Current Zoning: INST(CD) (Institutional, Conditional)
Proposed Zoning: INST(CD) SPA (Institutional, Conditional, Site Plan Amendment)

Approximately 40.43 acres located on the east side of Johnston Road, south of Providence Road West.

The petition proposes to amend a previously approved plan to allow for additional entitlements to a hospital and associated medical, dental, and optical offices and clinics. The petition would allow an additional 56,000 square feet in medical office uses and 13,000 square feet and 48 beds in health institution entitlements.

Exhibit A

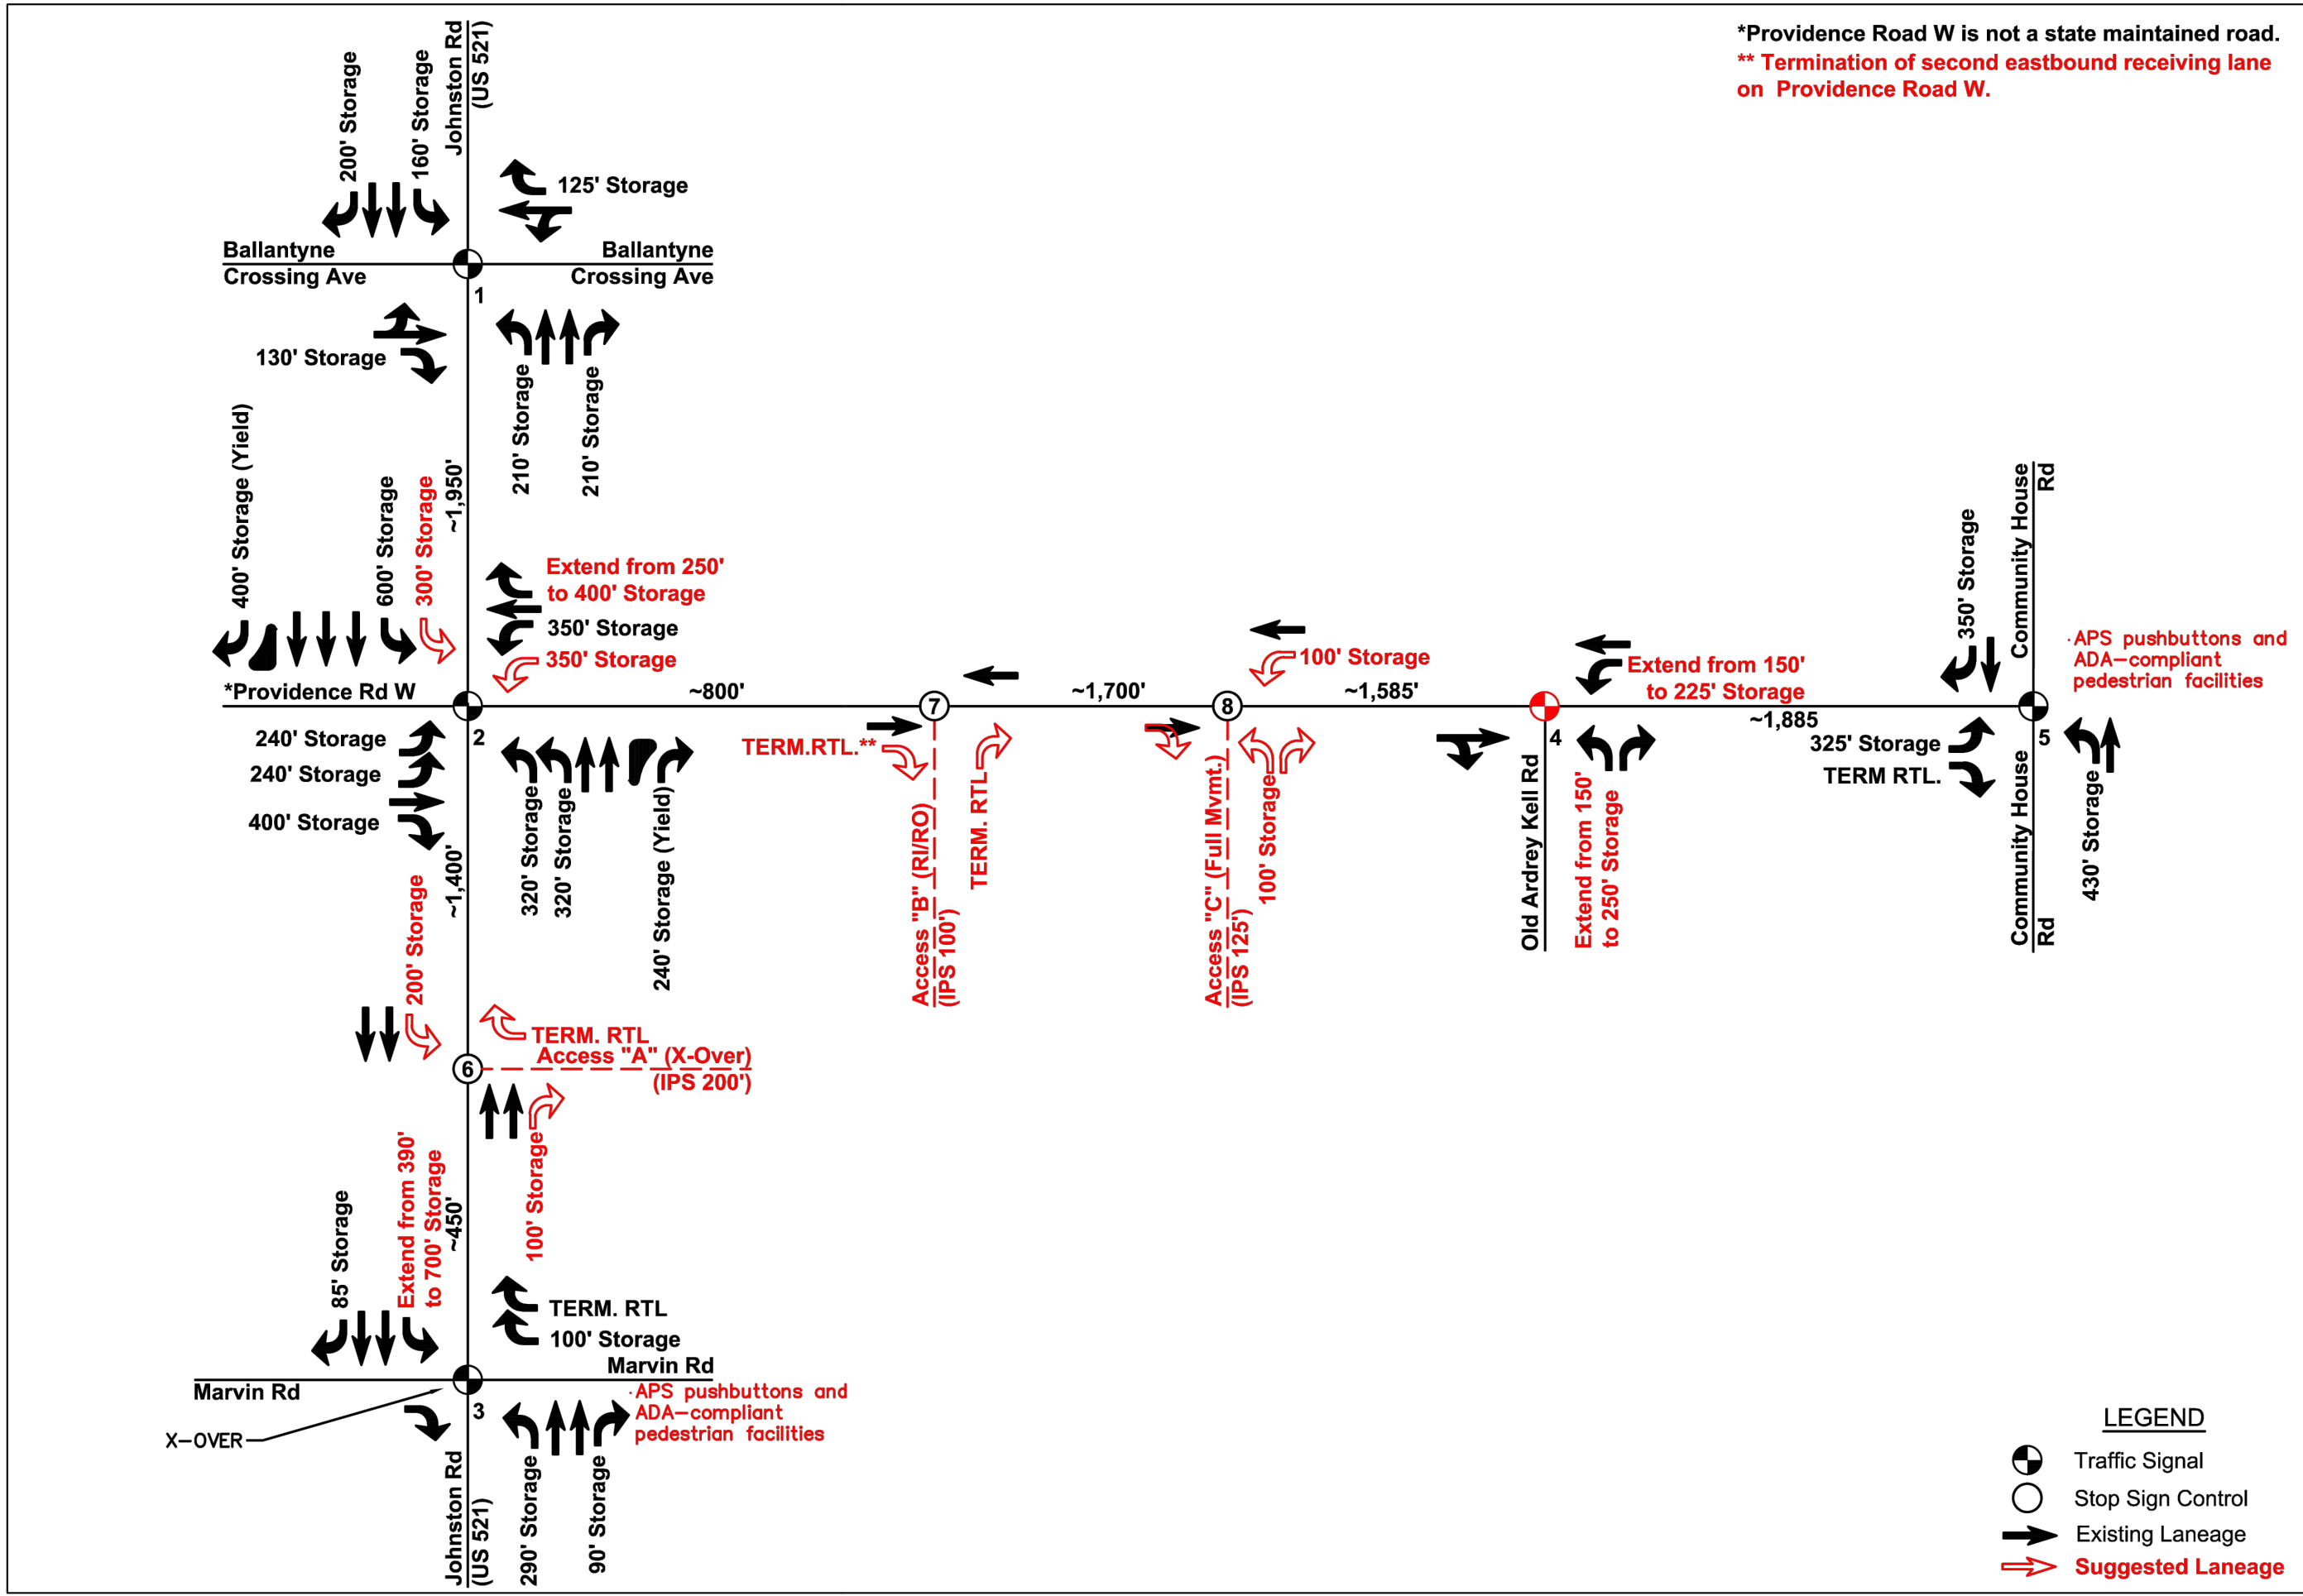
1. Update the site plan and Exhibit A to show the new leftover per updated TIS at "Access B".

2. ~~Reconcile the proposed medical office square footages proposed. The number listed in the conditional notes (106,946 SF) does not match what is listed in the traffic impact study (115,000 SF).~~
